MORGAN AND MORECAMBE OFFSHORE WIND FARMS: TRANSMISSION ASSETS

Works Plans - Onshore and Intertidal – Part 1 of 2

December 2024
Rev: F02

PINS Reference: EN020028
APFP Regulations: 5(2)(j)
Document reference: B8/F02

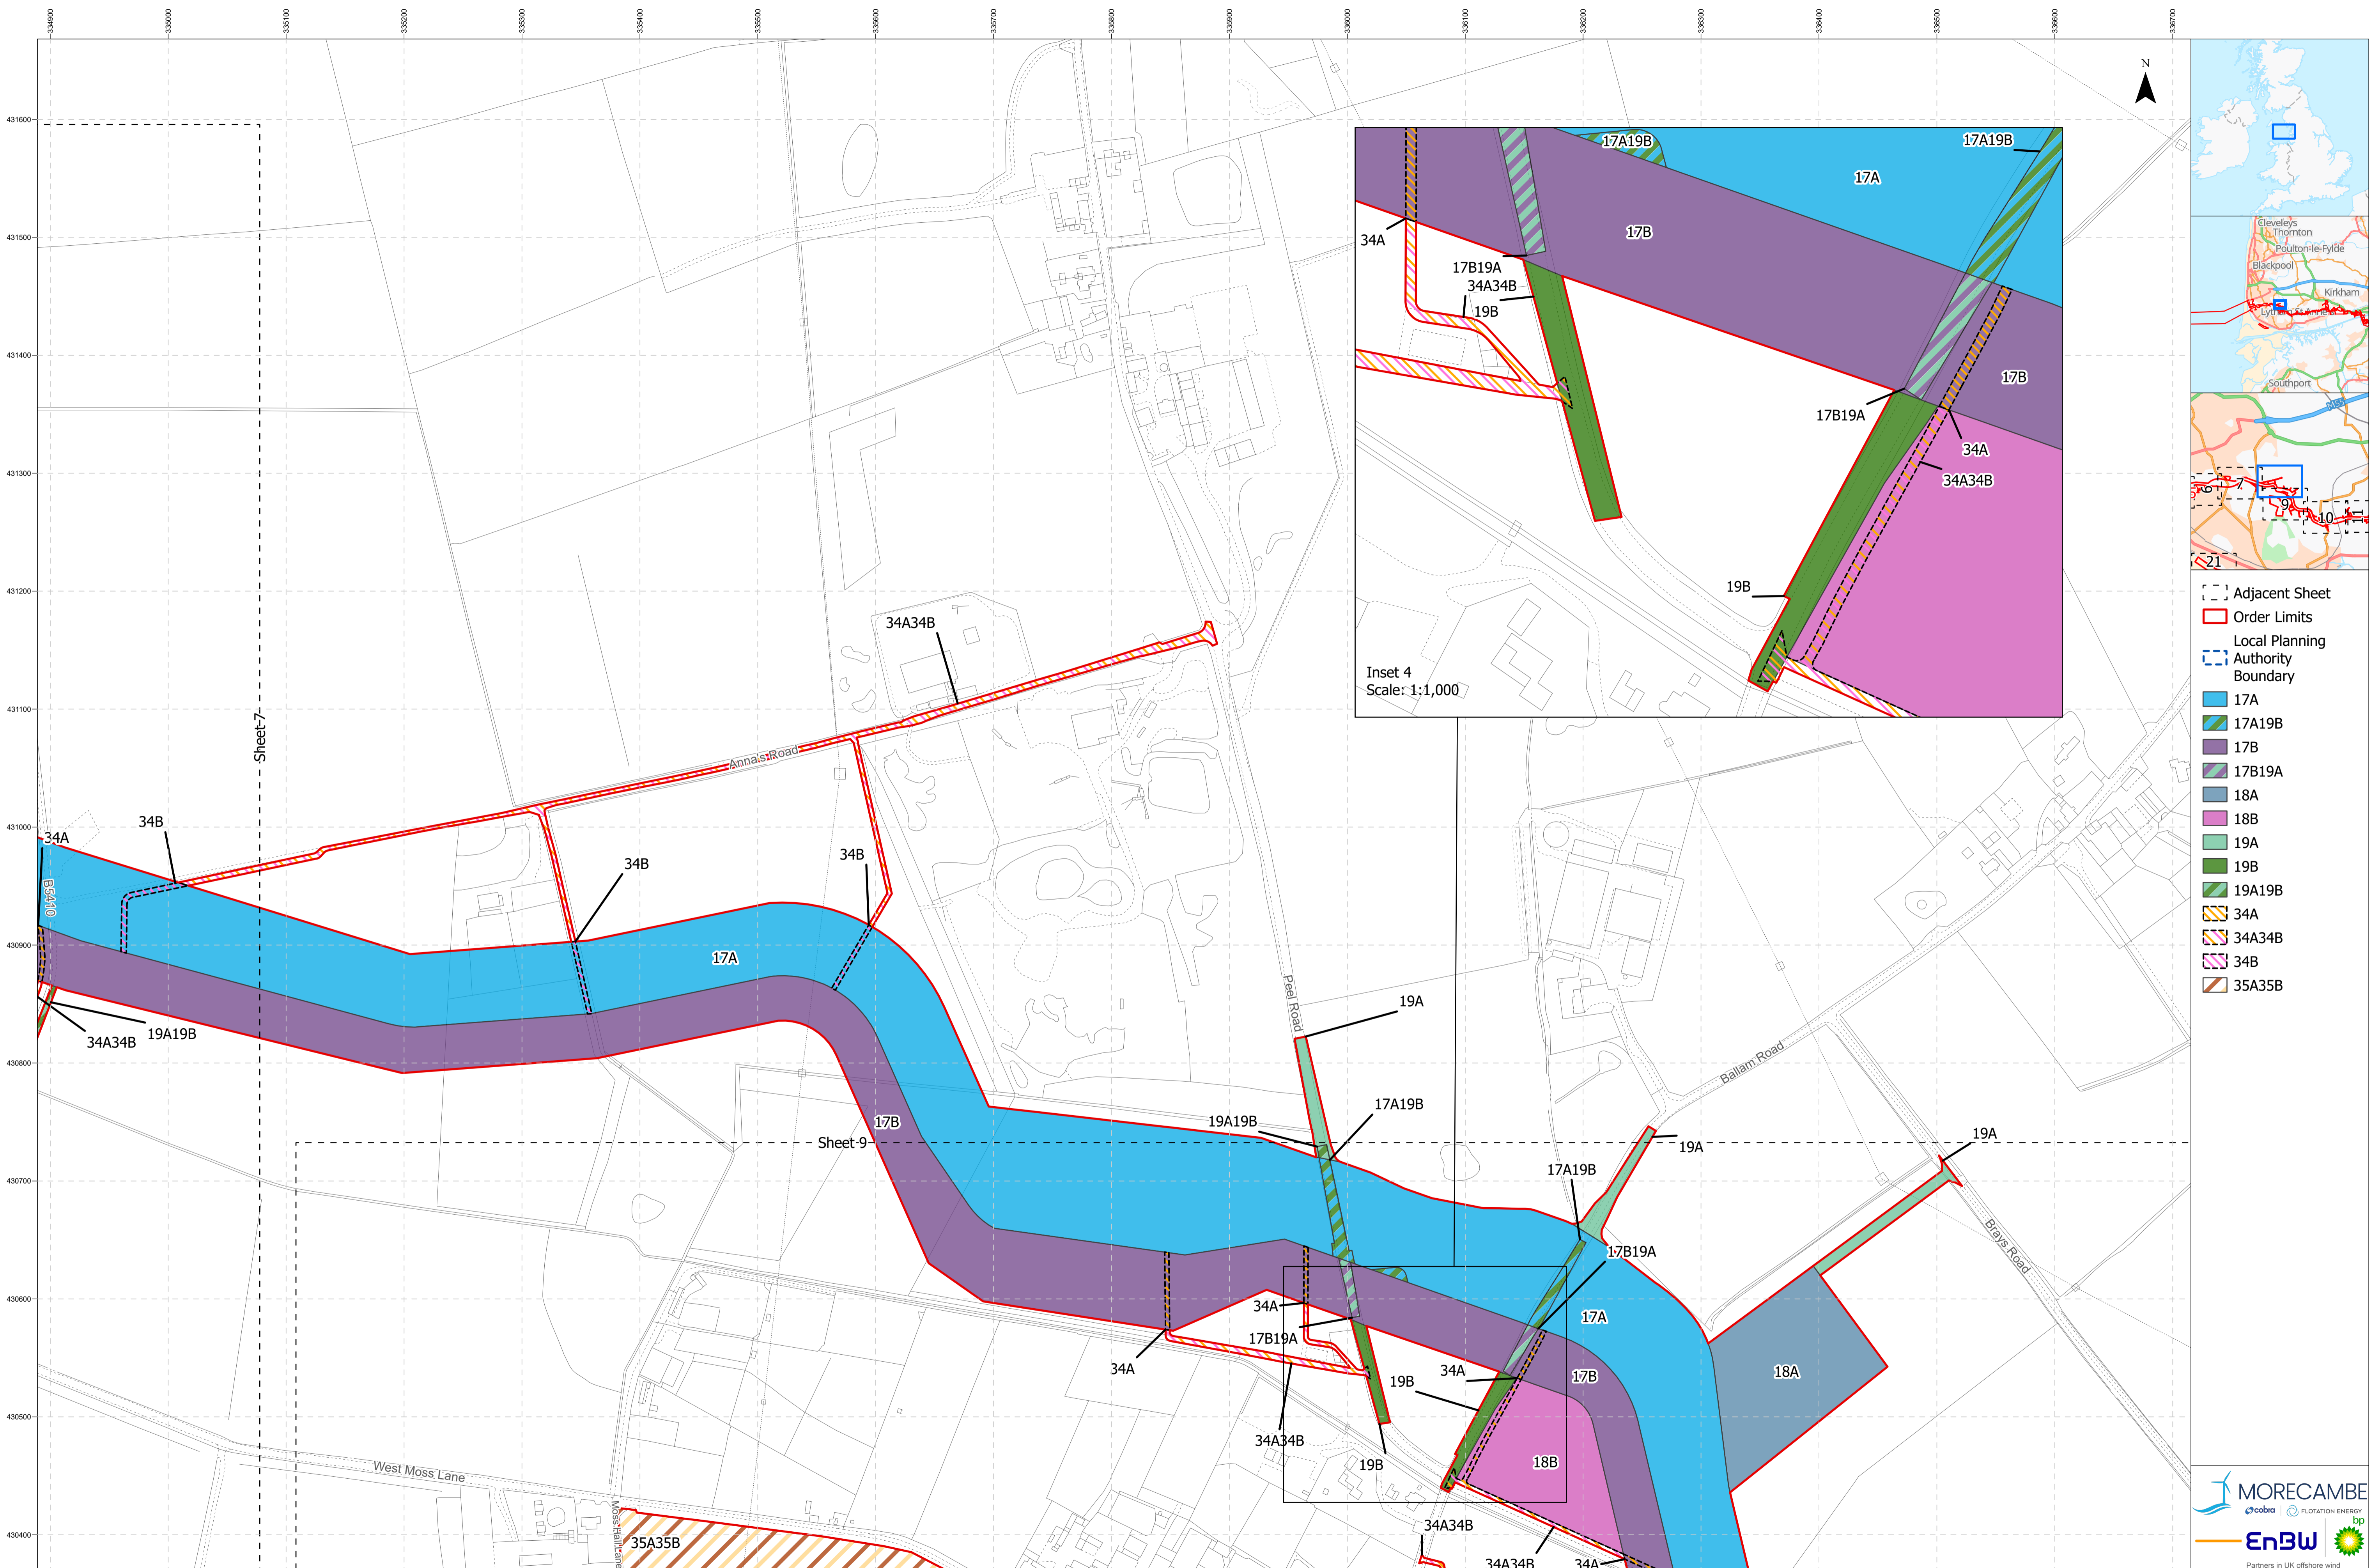
Sheet Number	Change requested by	Change Made	Reason for Change	Revision	Submission deadline
5	The Applicants	Permanent access (Work No. 34A) has been extended, near to Moss Sluice watercourse.	<p>A review of the works plans identified that permanent access (Work No. 34A) to Morgan's onshore export cable corridor (Work No. 17A) was previously omitted.</p> <p>This has now been updated to reflect the Morgan permanent access (Work No. 34A) to cable corridor (Work No. 17A)</p>	F02	S51 advice update
5	The Applicants	The permanent access (Work No. 34A34B) to both Morecambe and Morgan's onshore cable works (Work No. 17A and 17B) has been refined west of Midgeland Road.	<p>A review of the works plans identified that permanent access (Work No. 34A) did not need to extend over Morgan's onshore export cable corridor (Work No. 17A). Similarly, permanent access (Work No. 34B) did not need to extend over Morecambe's onshore export cable corridor (Work No. 17B).</p>	F02	S51 advice update

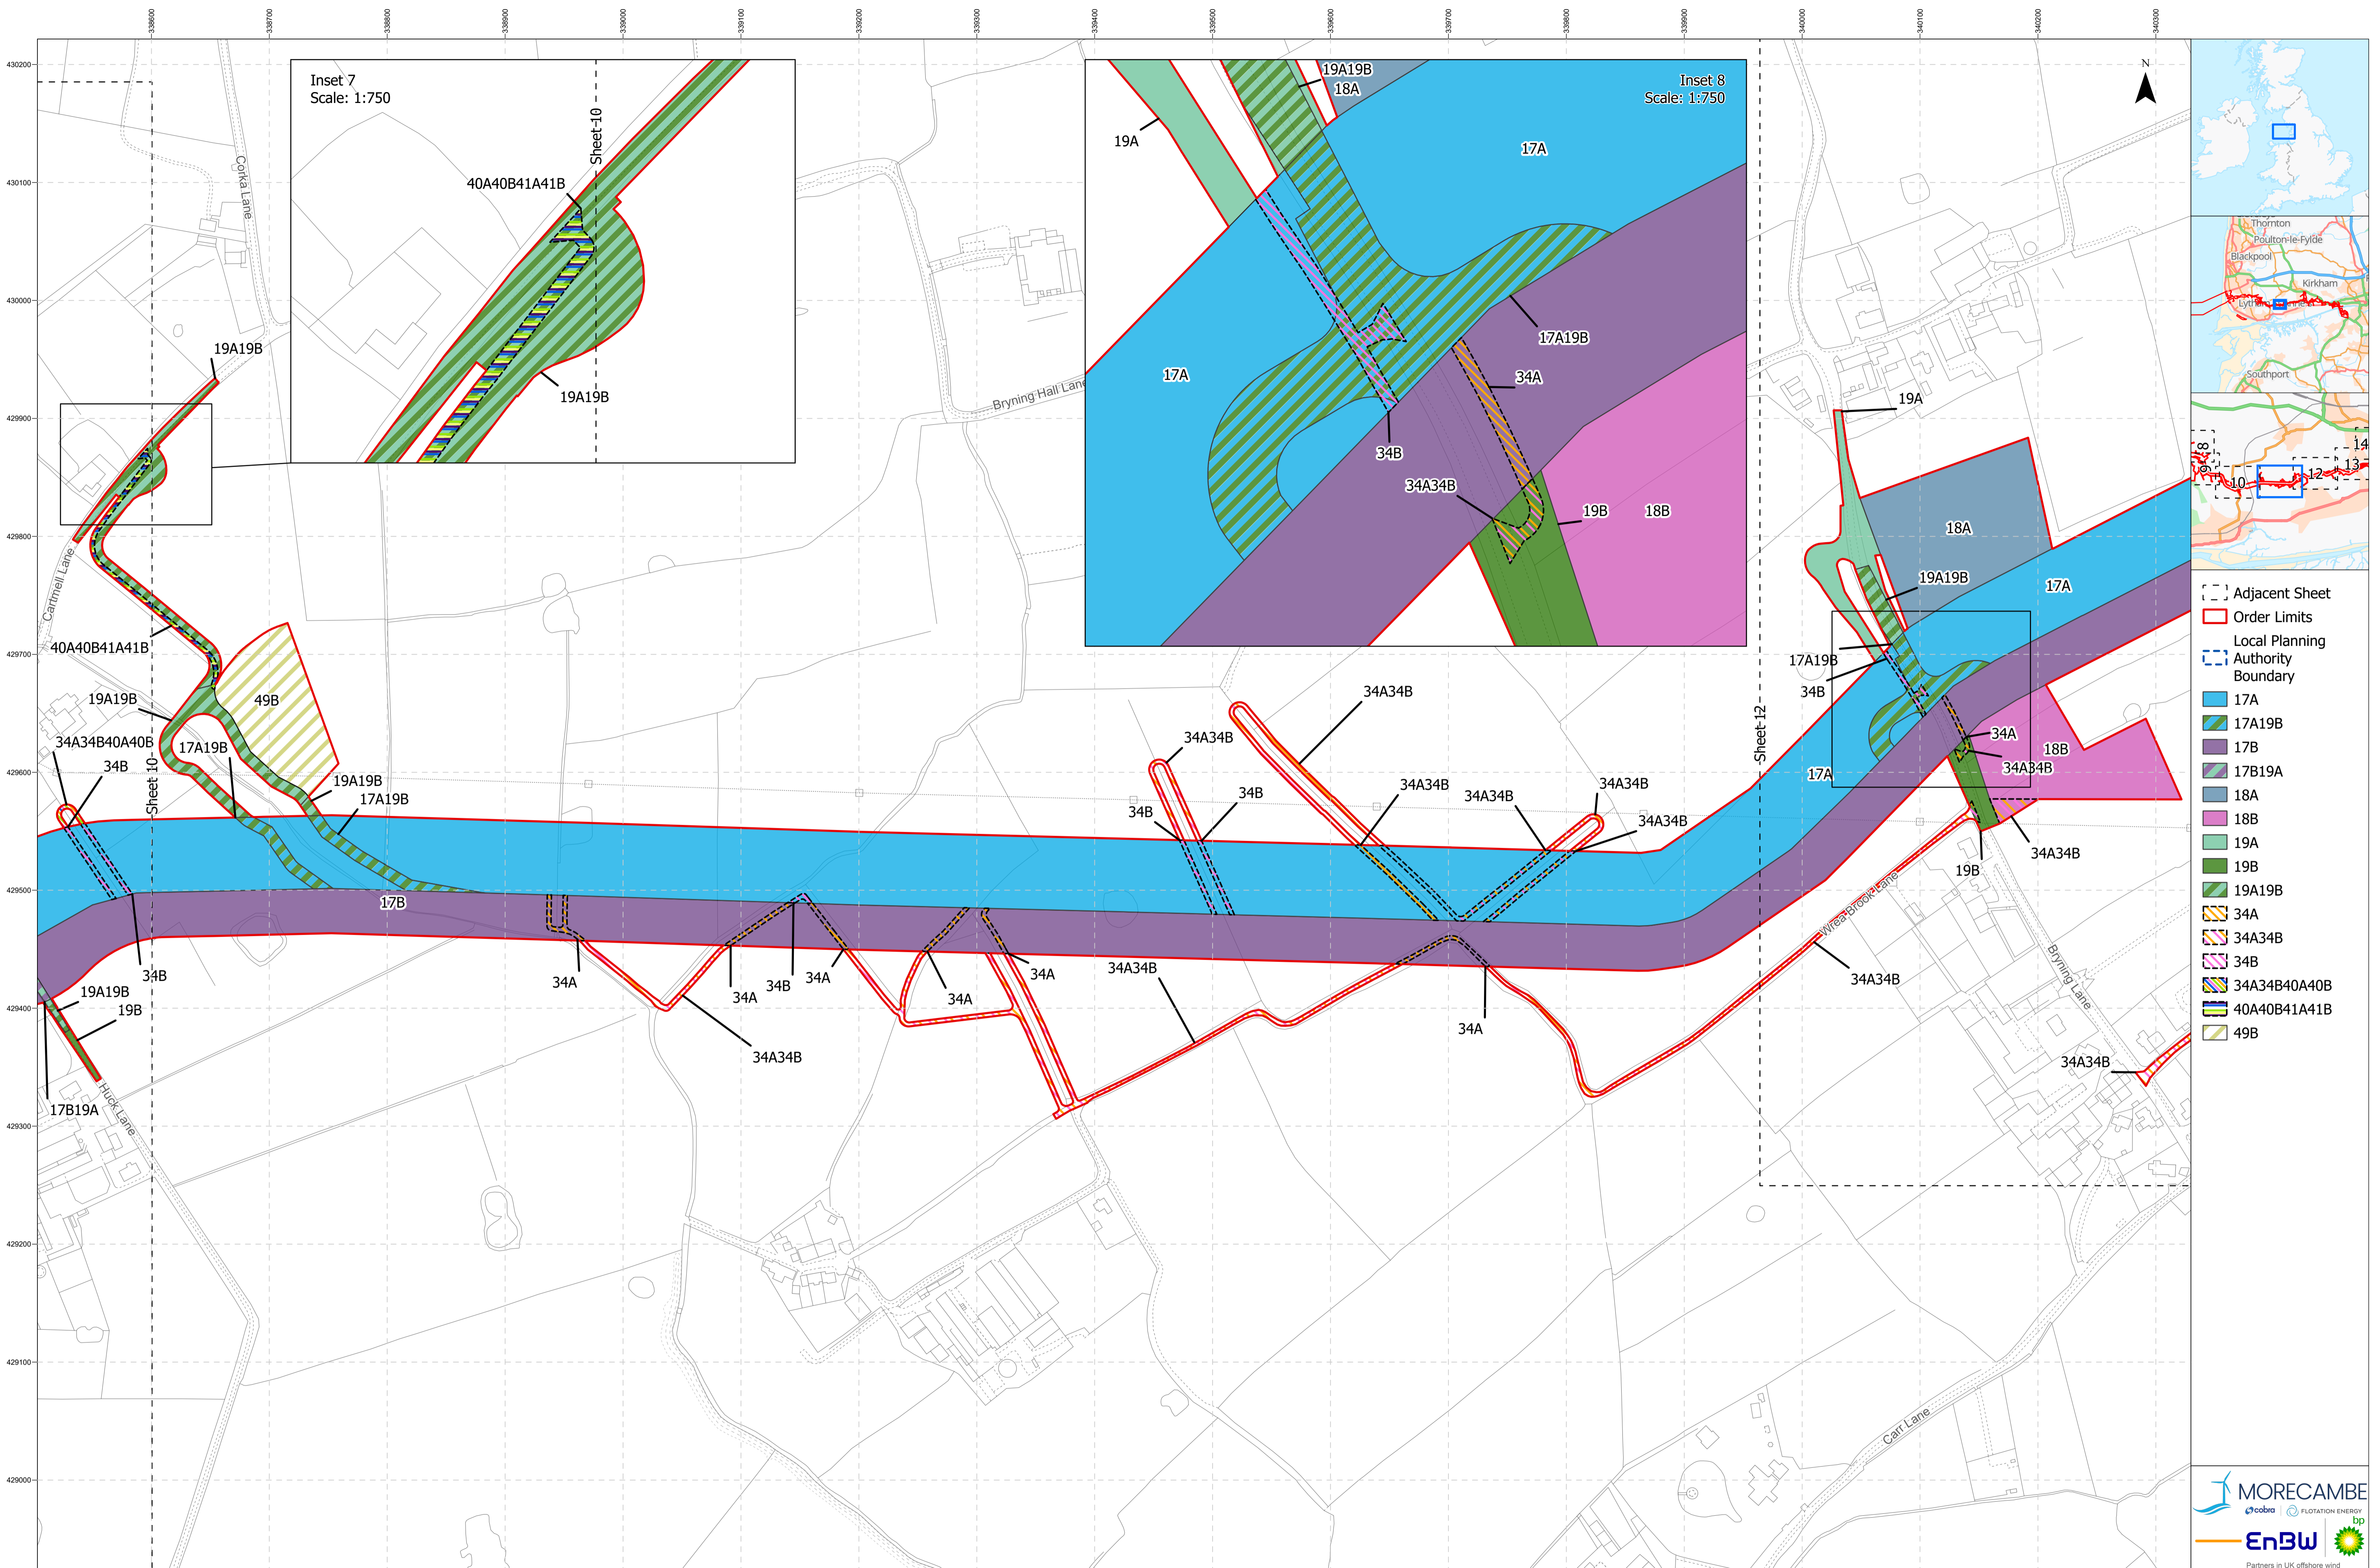
8	The Applicants	Construction access to environmental mitigation works (Work No. 40A40B) has been removed, south of Cartmell Lane.	<p>A review of the works plans identified that construction access to environmental mitigation works (Work No. 40A40B) was not required at this location.</p>	F02	S51 advice update
9	The Applicants	Morgan construction and permanent access to environmental mitigation works (Work No. 40A41A) has been remove off Cartmell Lane.	<p>A review of the works plans identified that construction and permanent access to environmental mitigation works (Work No. 40A41A) was not required at this location.</p>	F02	S51 advice update
